Lake House – Corrections Response Letter

Building Plan Reviewer: **City of Mercer Island**

Response to: 2012-200 Lorenzini Remodel 2R
Dated: June 17, 2021
Permit #: 2012-200
Project address: 3310 97th Ave SE
Mercer Island, WA 98040

Re: *Lorenzini Remodel (Lake House) at 3310 97th Ave SE Permit No. 2012-200*

1 GARAGE SECTION
1/2" = 1'-0"

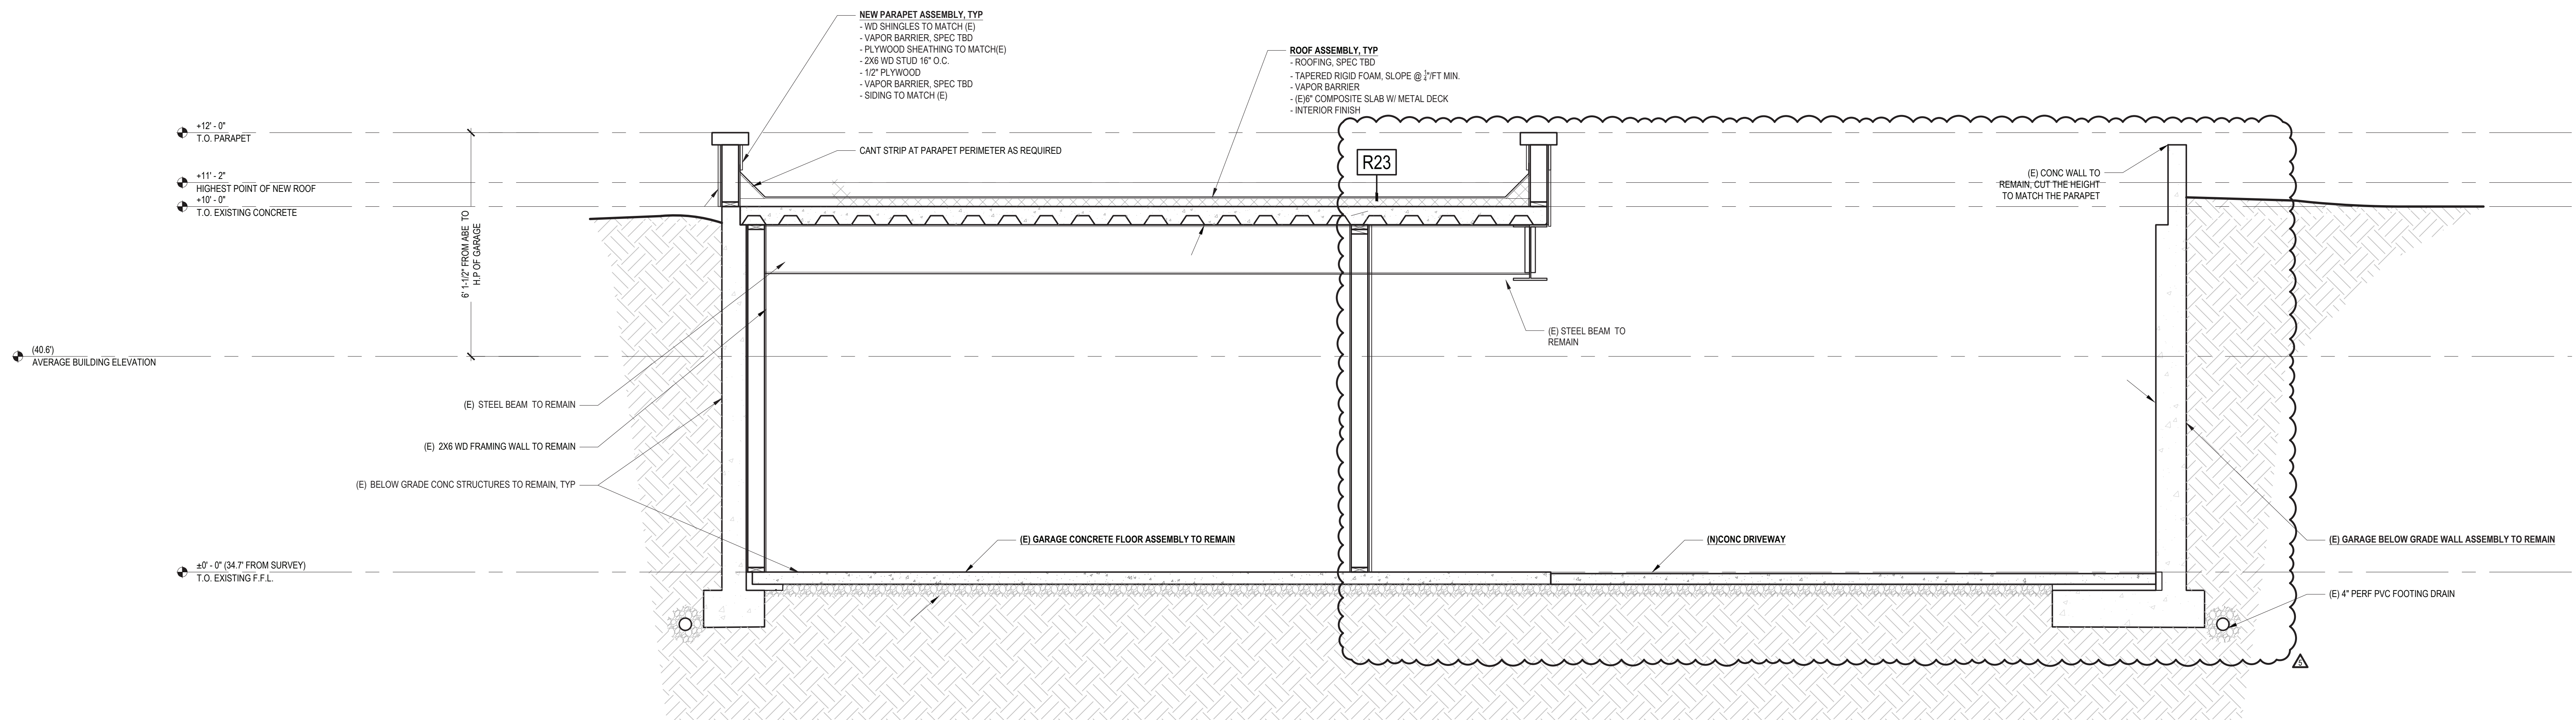
10. The attic vent graphic on Sheet T1.02 shows a portion of the garage with an unvented roof. The structural drawings also imply an unvented roof; see the Roof Framing Plan on Sheet S2.2 and Details 16 & 18/S4.1 which show the insulation above the plywood sheathing. We do not find that Building Section 1/A4.02 is showing the unvented portion of the roof over the garage correctly. Please update the section and reference the appropriate Roof Type as R7 does not appear correct.

12. Building Section 1/A4.02 is cut through Garage 101; however, we have some questions in regard to the separation at the dwelling to show compliance with IRC R302.6. As noted above, it appears this section is not drawn correctly. Please revise as needed. Additionally, since the attic above the garage is to be considered part of the dwelling, then 5/8" Type "X" GWB should be provided at the underside of the roof trusses.

- See 1/A4.02 for updated roof at Garage.

- Min. code requirements for GWB between garage and attic space is 1/2", thus no need to change the GWB around the garage.

S2.0

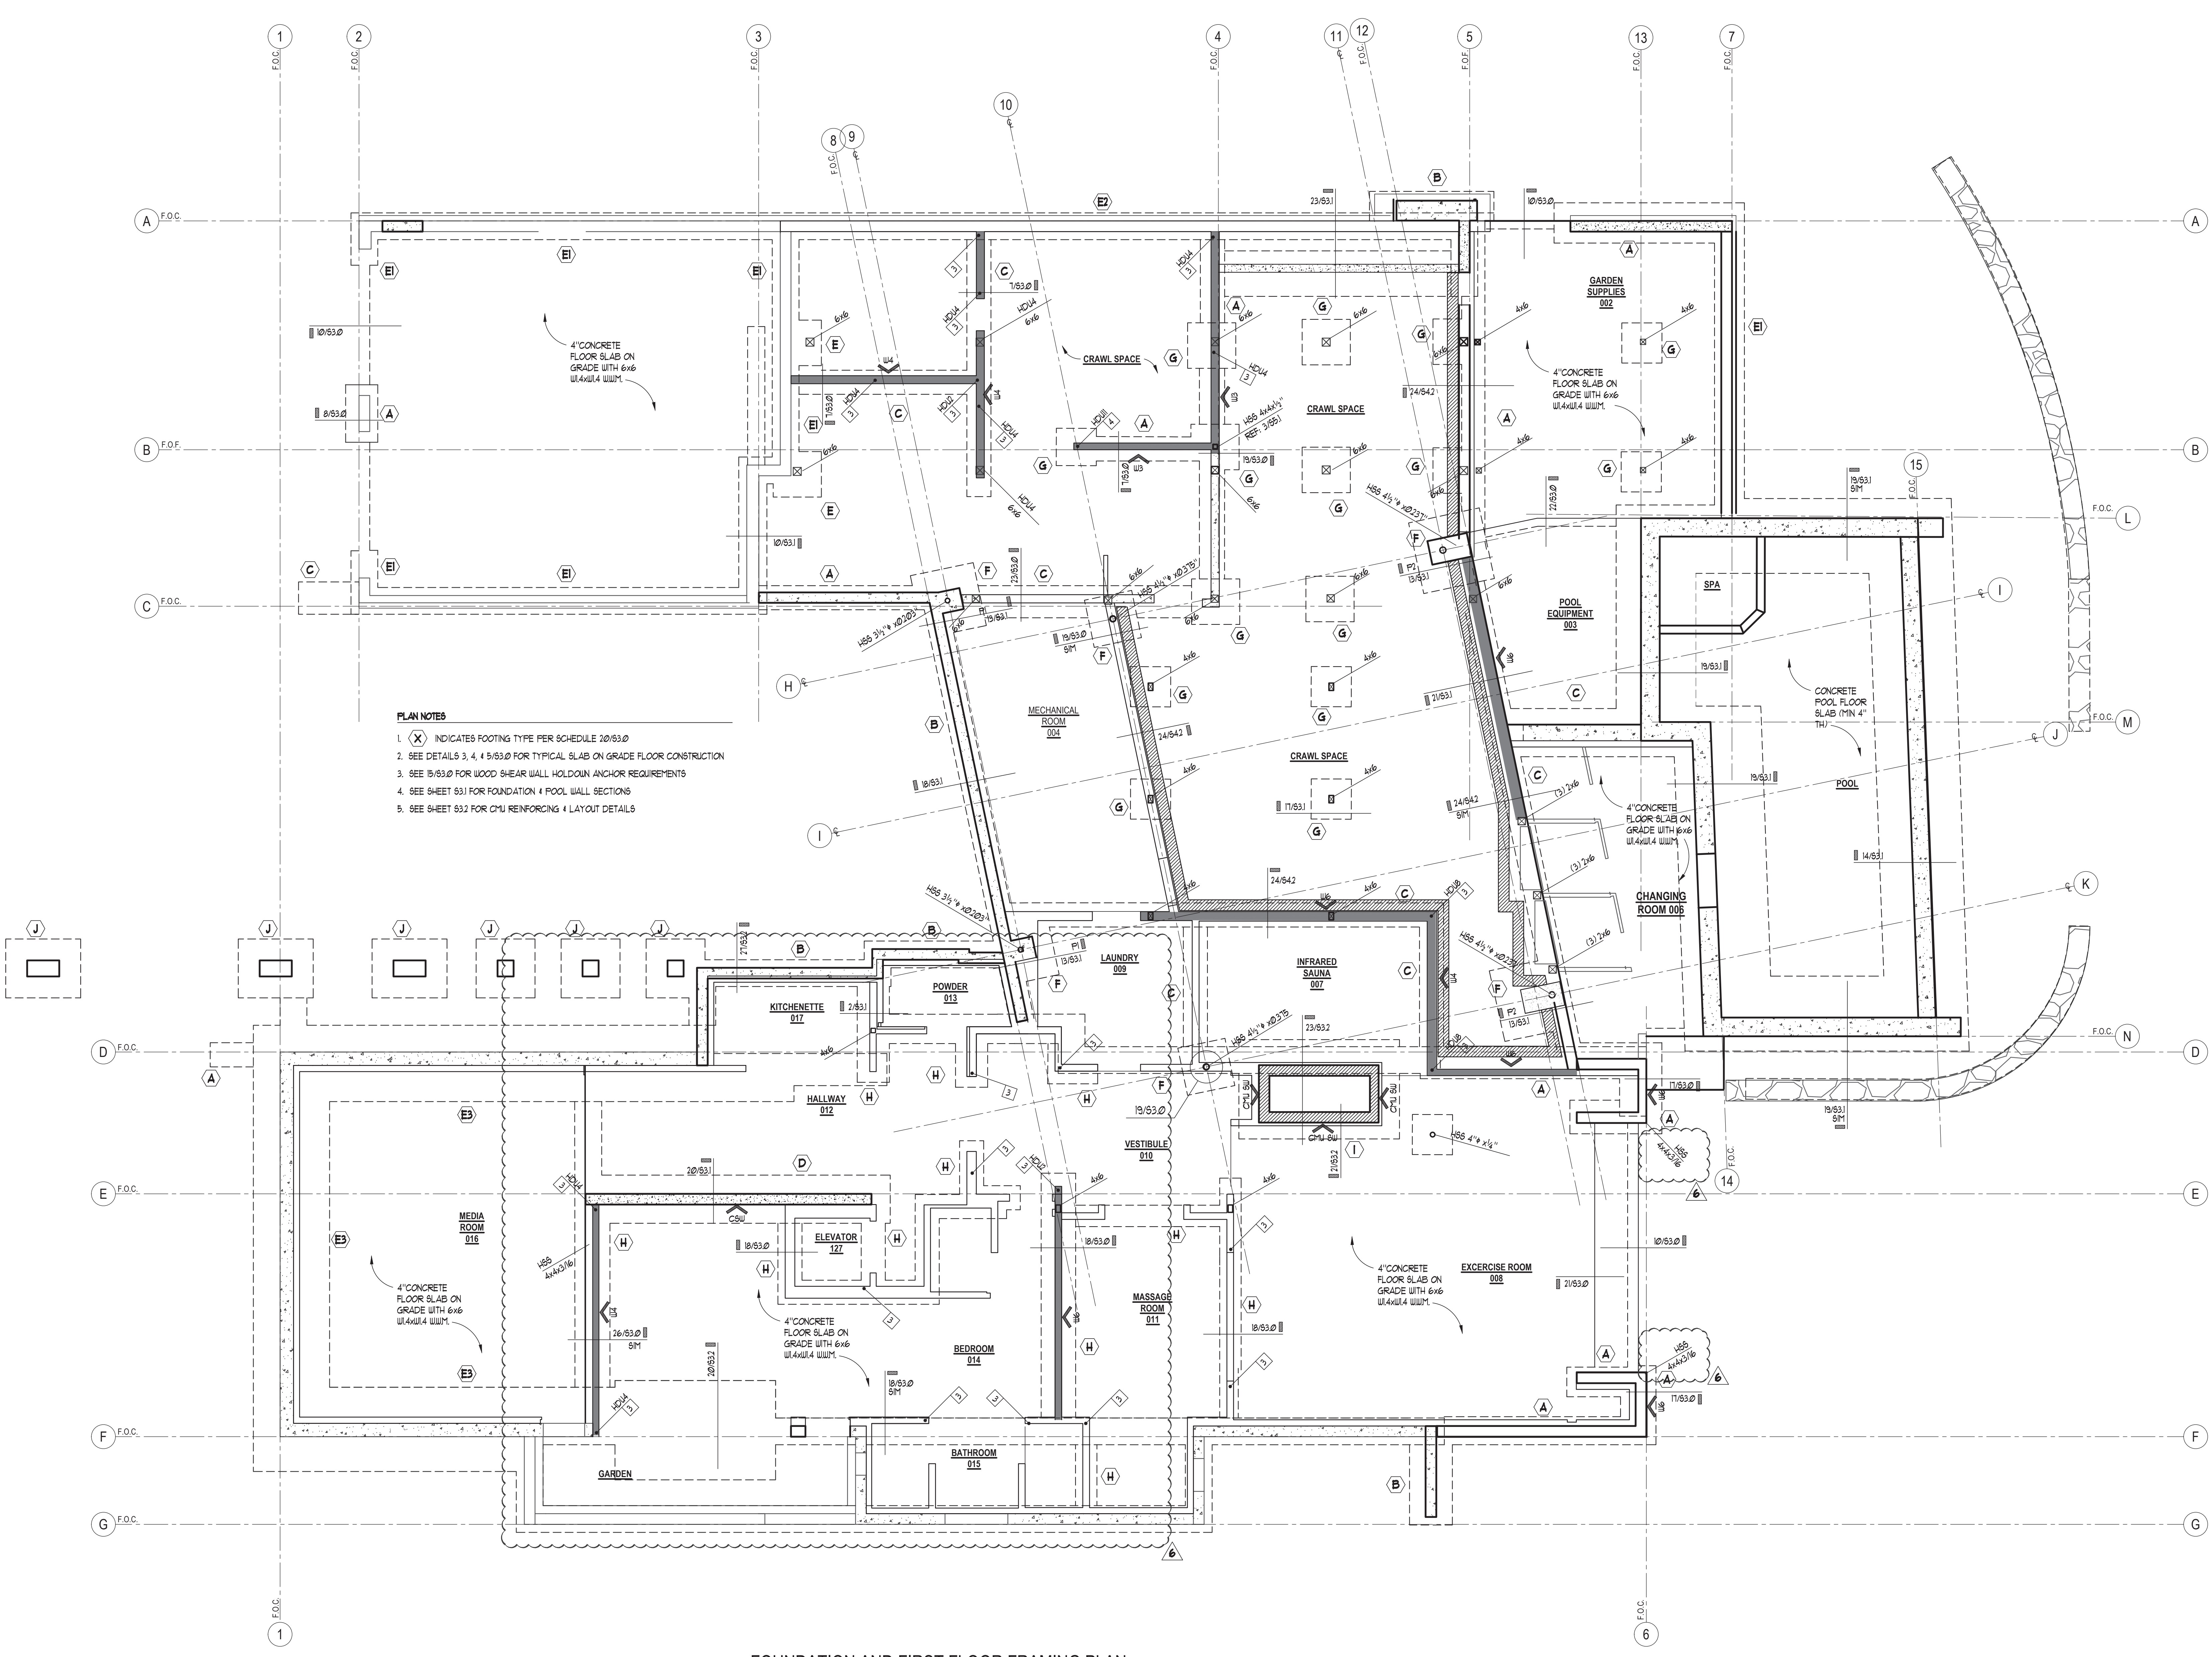
3. Detail 23/S3.2 is cut on the Foundation Plan, Sheet S2.0, at the fireplace, but Detail 23/S3.2 is not a section through the foundation. Provide a relevant detail to show compliance with IRC R1001.2.
Detail 21/S3.2 has been added to the plan set and referenced on S2.0 and 23/S3.2 to clarify the foundation dimensions below the fireplace.

- a. The calculations indicate holdowns are required at the lower level; we only find a holdown on the north end of the wall on Sheet S2.0.

- b. The upper level wall holdown should be continued to the foundation. Refer to the MSTC40 on Sheet S2.1.

- b. Similar to the above, the lower level column serves as a holdown. Please reference the intended detail at the same location on Sheet S2.0.

At the main floor, the south end of Shear Wall B aligns with the foundation wall at the edge of the garage, so an HDU4 holdown was placed at the main floor in this location to anchor directly to the foundation wall below the main floor. The HDU2 located at the north end of the wall is in the crawl space as the foundation is only a shallow spread footing at this end.

An HDU4 holdown has been located below the MSTC40 strap on S2.0

A reference to 3/S5.1 has been added to the column on S2.0
